Against - Annex Website Submissions for job City East Zone Substation Project Application 2A(i)

With its giant atrium, the previously proposed approval for this site would have brought life and light back to Richard Johnson Square. With its 8 storey blank wall, the current proposal will kill Richard Johnson Square forever. What a disgrace.

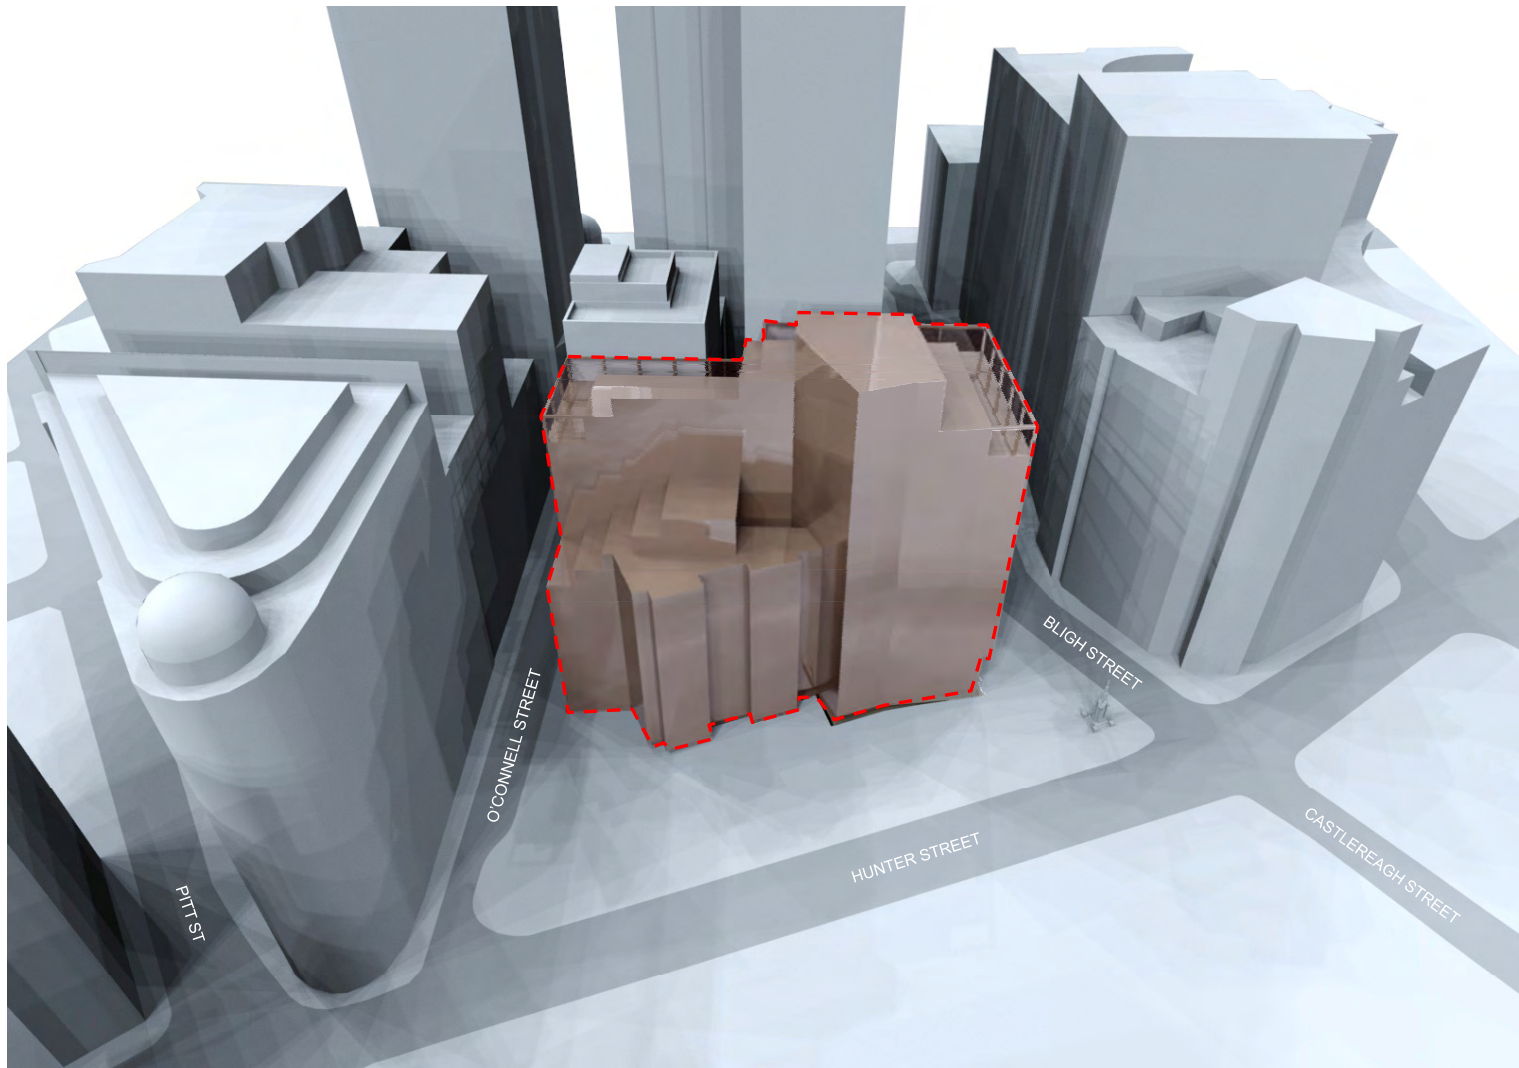
No developer would get away with such an inactive street front in such an important part of the CBD and nor should Energy Australia. Perhaps its time Energy Australia contribute something to the city other than electricity.
